**WEST SUSSEX COUNTY COUNCIL
STRATEGIC PLANNING CONSULTATION**

SUBJECT: BE/23/14/PL

**Change of use from Class B8 (Storage or Distribution) to Class A1 (Shops)
including partial demolition.**

**Adjacent warehouse site to McDonalds, Oldlands Way, Bersted, West Sussex,
PO22 9SA**

Site Plan as Proposed

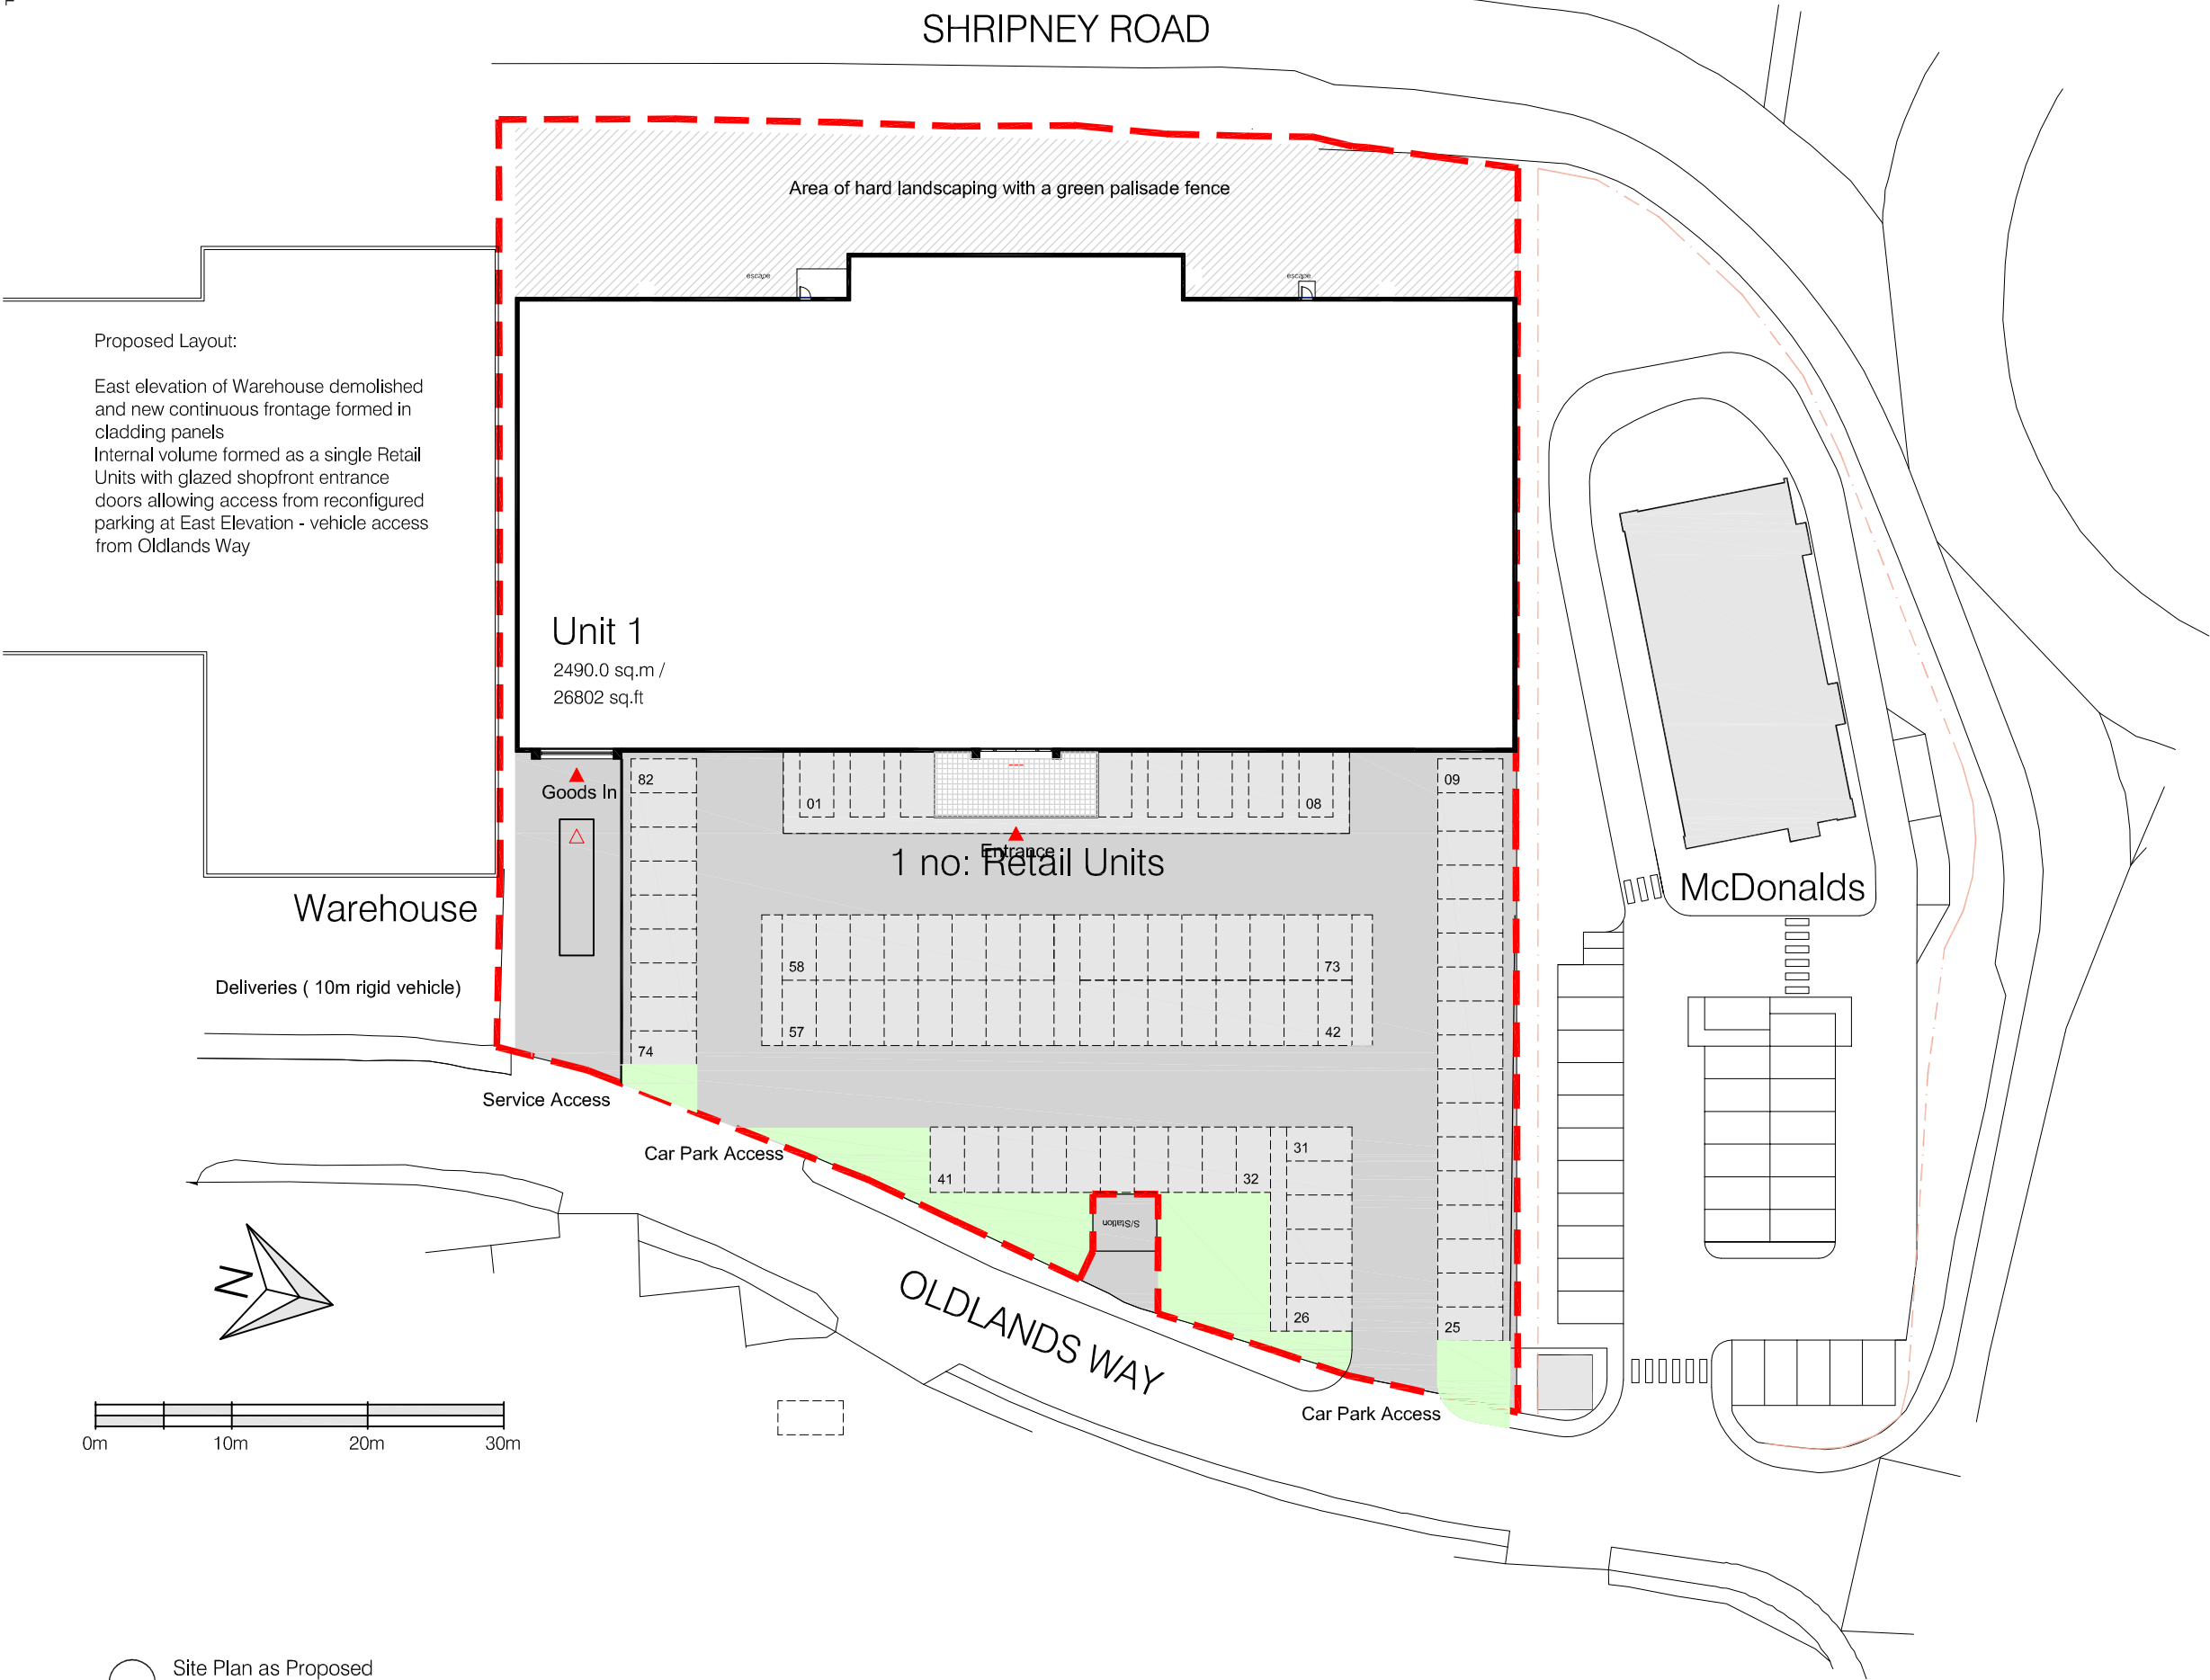
The proposals include revised access arrangements; while there appears to be a good level of visibility, splays should be provided on the access plans from a setback of 2.4m and in accordance with Manual for Streets guidance within either land owned by the Applicant or within the highway boundary.

The location of parking in the proximity of the access could result in the vehicles exiting the spaces coming into conflict with vehicles accessing the site, or result in Oldlands Way becoming obstructed unexpectedly while vehicles wait for the vehicles exiting the space.

The plans do not appear to indicate a route for pedestrians from Oldlands Way, who would instead be expected to share the internal car park roads. Provision should be made to provide a dedicated provision to encourage the use of sustainable modes. In addition, there appears to be no provision to encourage cycle journeys such as sheltered and secure parking.
